Project: 2111 Webster Elementary Remodel
445 Jersey Lane
Colorado Springs, Colorado 80911

RFI #186: Storm Pipe in Concrete

C8.0

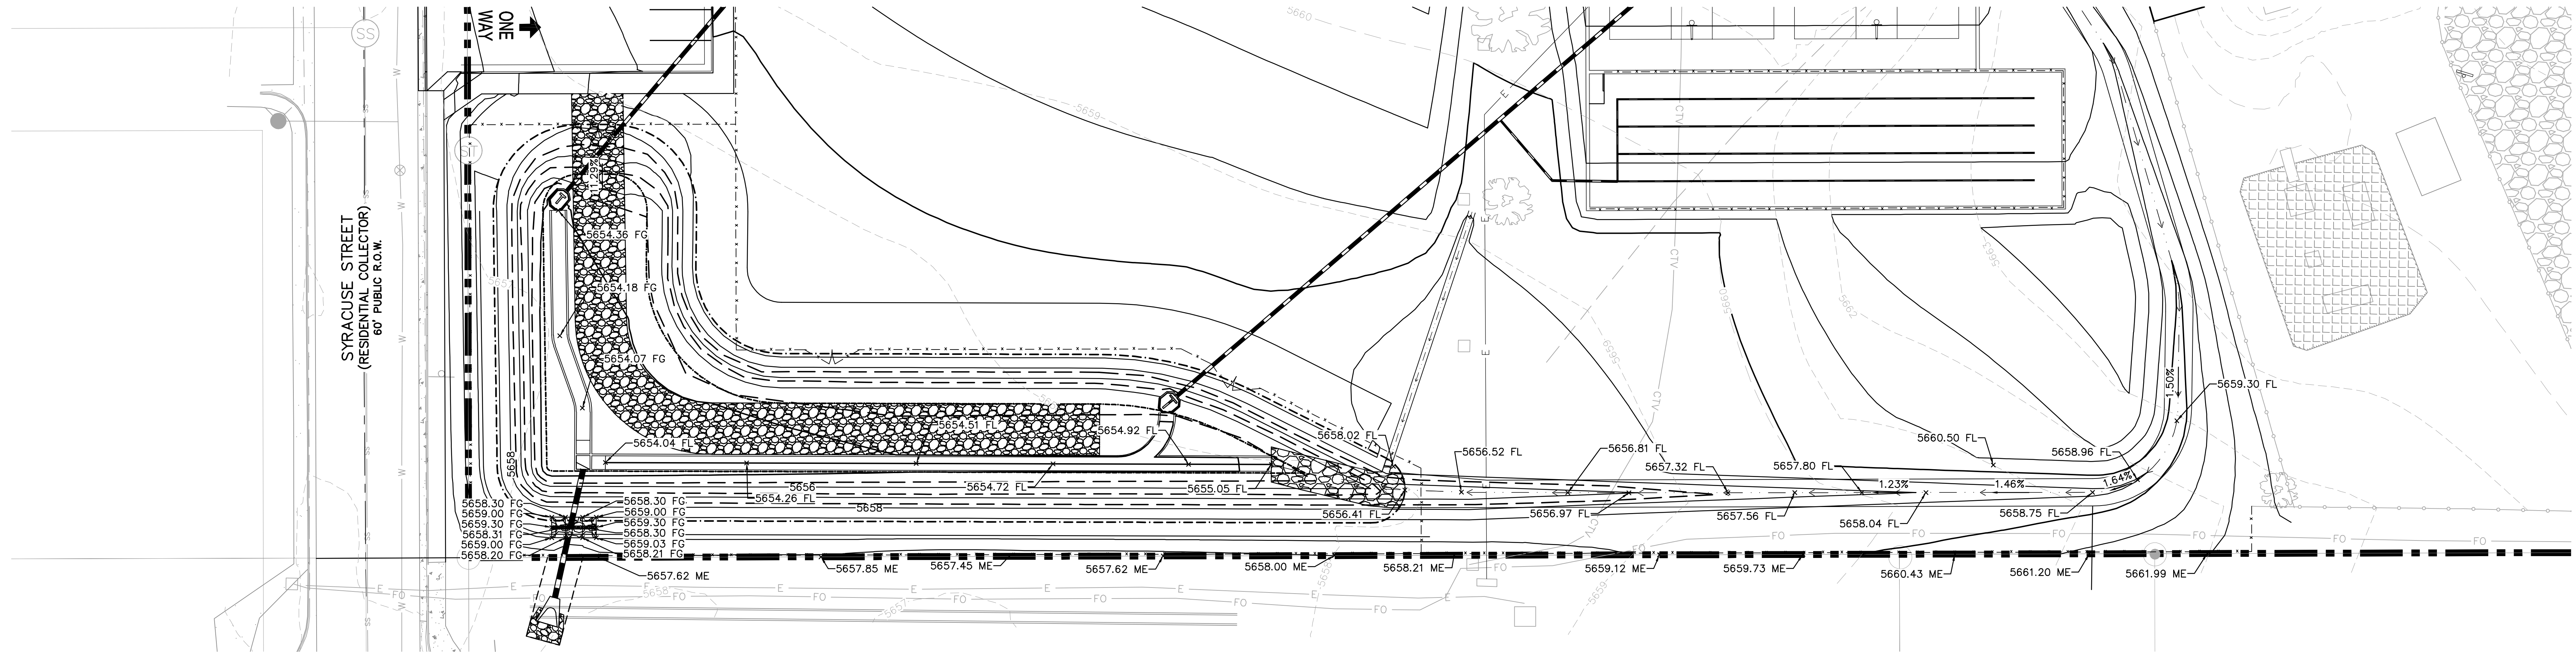
Drawing C8.0 shows the finish grade elevation of the emergency overflow cut-off wall to be 5659.30', and the wall detail on C8.1 shows the bottom of footer 4.5' below finish grade. This would put the bottom elevation of the concrete at 5654.80'. The flow line elevation is 5654.00' and the pipe is 18", making the top elevation of the pipe 5655.50'. This would put the pipe approximately 7" into the concrete. Is it acceptable for the pipe to sit in the concrete foundation of the emergency overflow cut-off wall?

Yes, this is acceptable.
